From: Paul Cann <Paul.Cann@arun.gov.uk>
Sent: 04 June 2020 11:40
To: Planning.Responses <Planning.Responses@arun.gov.uk>
Cc: Sarah Burrow <Sarah.Burrow@arun.gov.uk>
Subject: RE: Planning Consultation on: BN/56/20/PL

Engineers Comments Regarding Surface Water Drainage

Application No: BN/56/20/PL
Registered: 2nd June 2020
Site Address: 33 Hill Lane Barnham PO22 0BL
Grid Reference: 496376 103708
Description of Works: Demolition of existing shed/garage & erection of 1 No detached dwelling. This application affects a Right of Way.

Site Block Plan
1:500

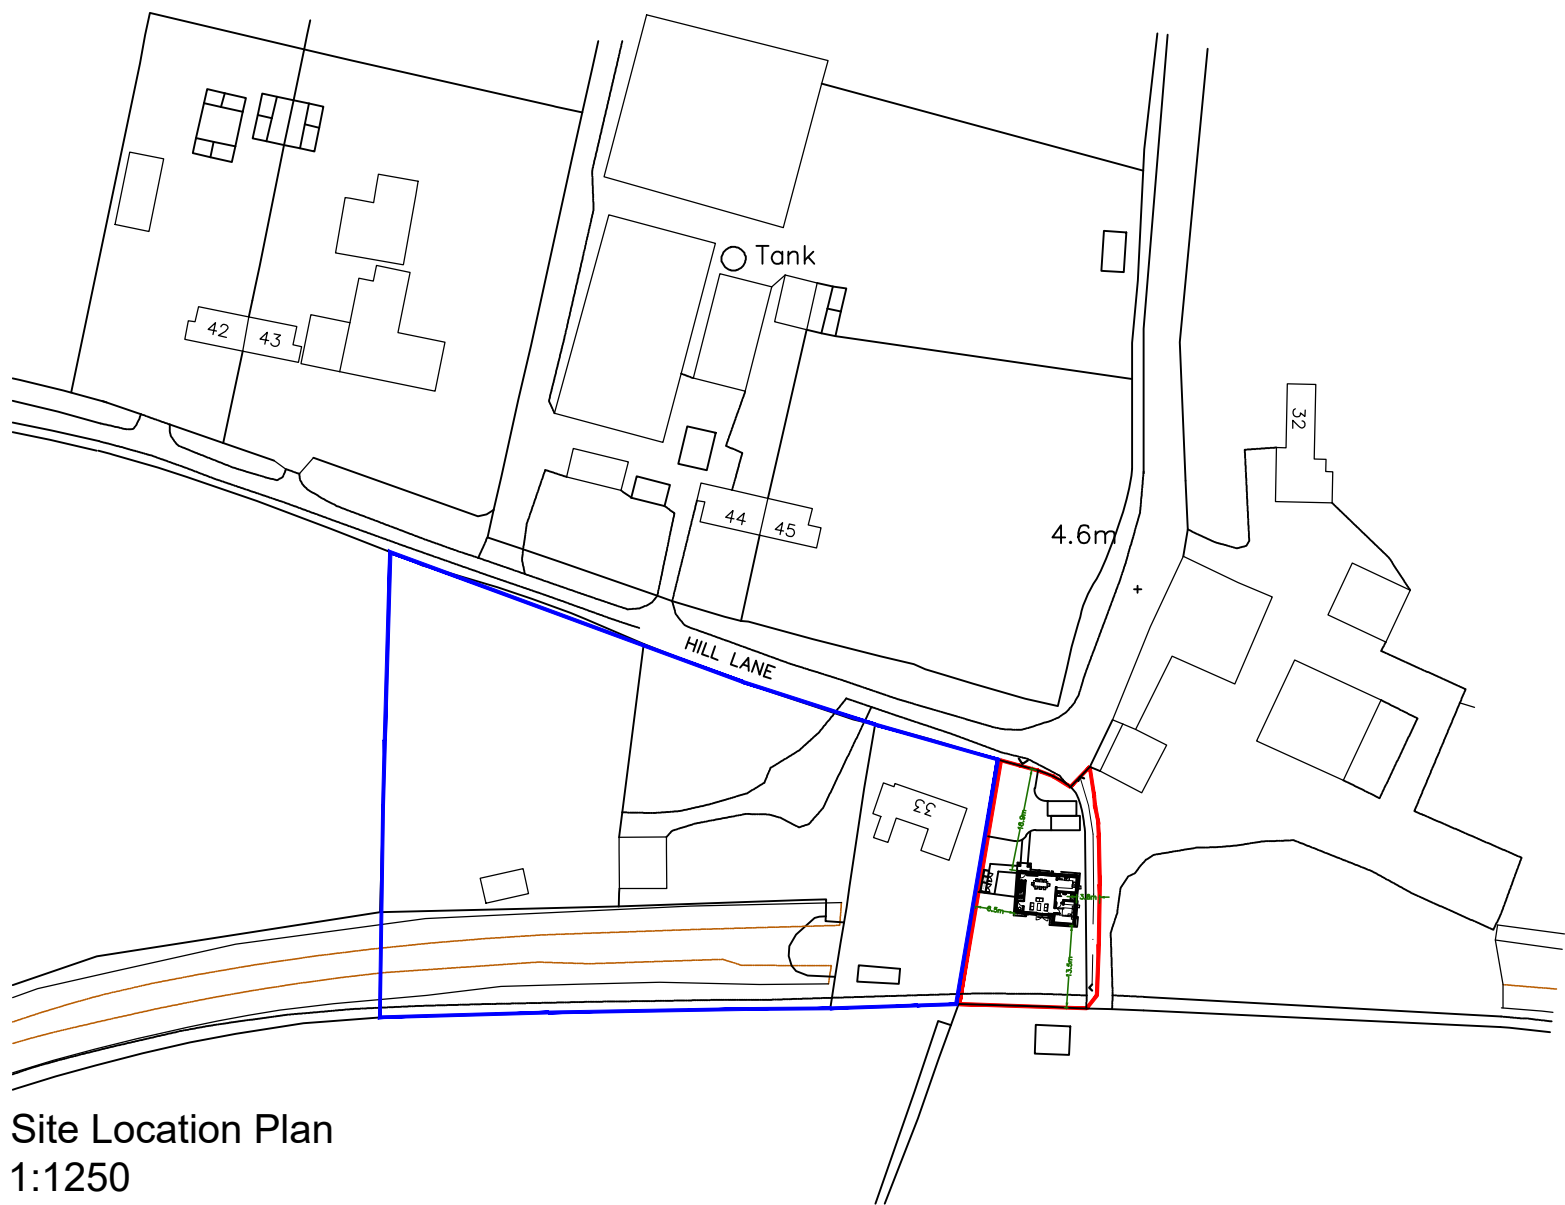
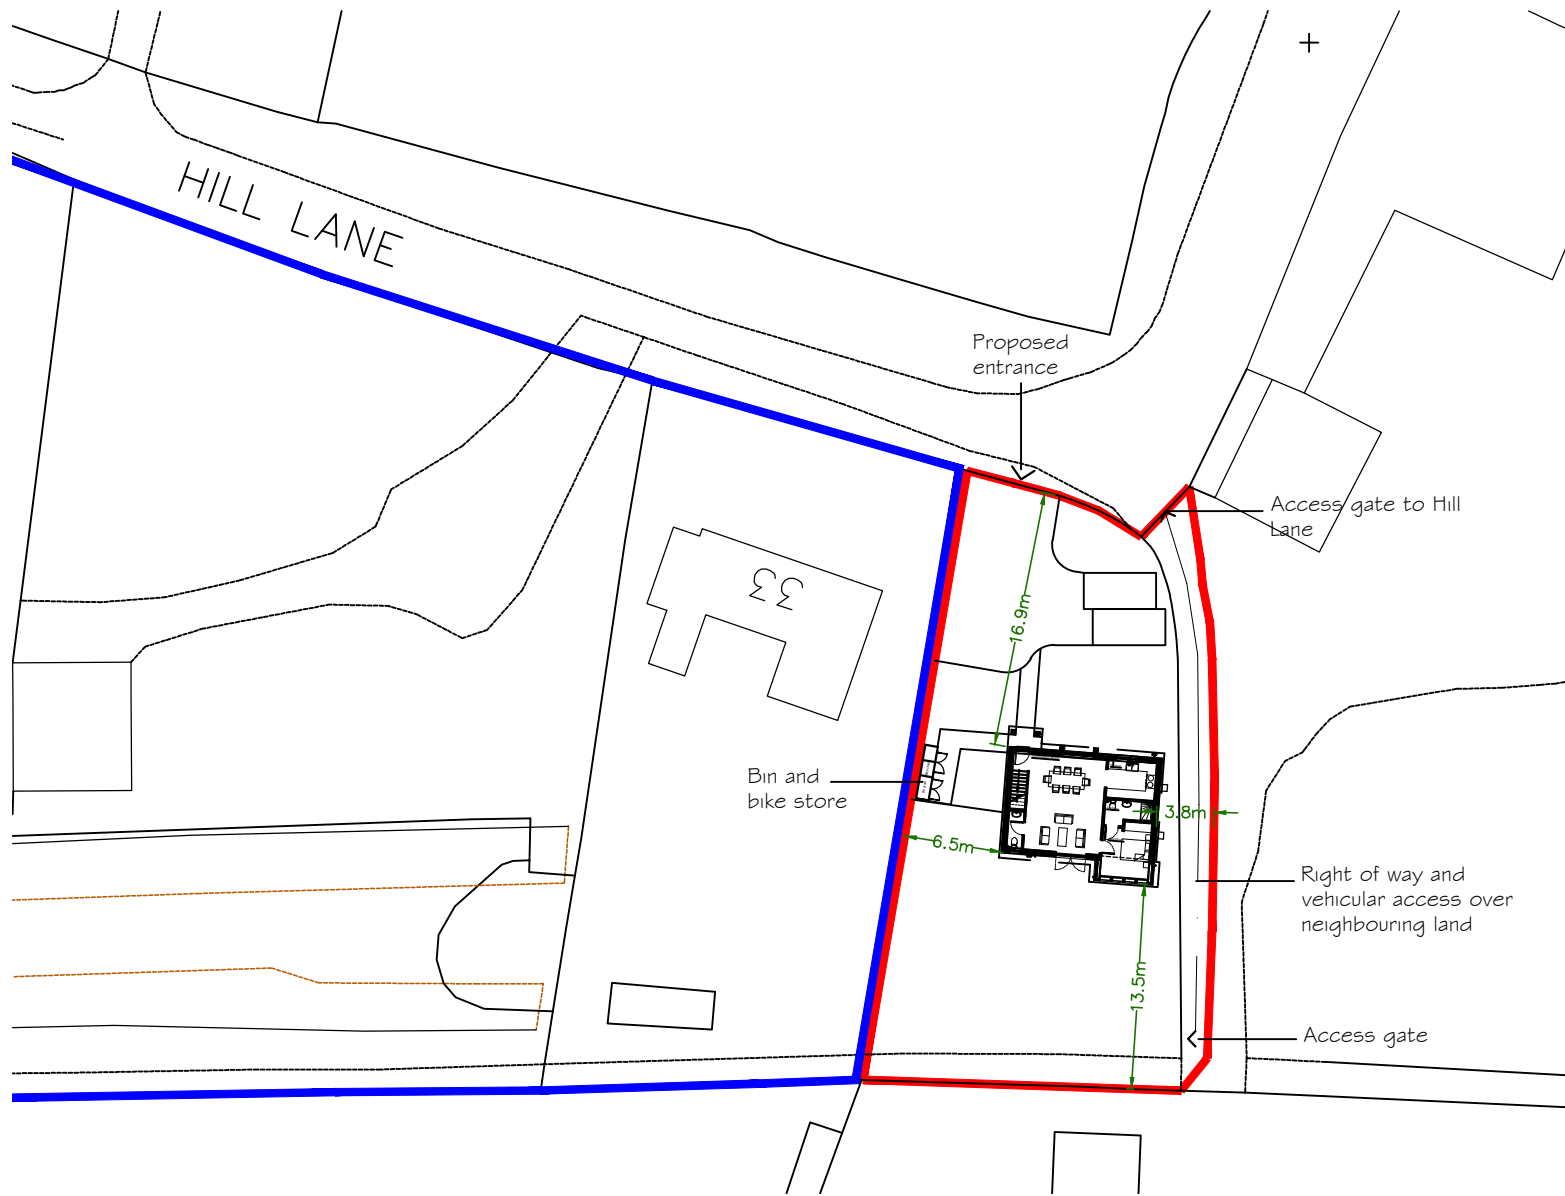
The applicant is aware that a culverted watercourse crosses the site. All buildings, structures and fences etc to be kept at least 3 metres from the edge of the culvert. No tree planting to take place that will have a detrimental effect on the culvert.

I note the applicant is proposing a sewage treatment plant for the disposal of foul water. There is mains drainage in the vicinity but maybe difficult to connect to. However, the applicant should investigate this option in liaison with Southern Water. If a connection to mains drainage is not possible, then a permit maybe required from the Environment Agency and Land Drainage Consent will be required from ourselves for any connection of treated effluent to the watercourse.
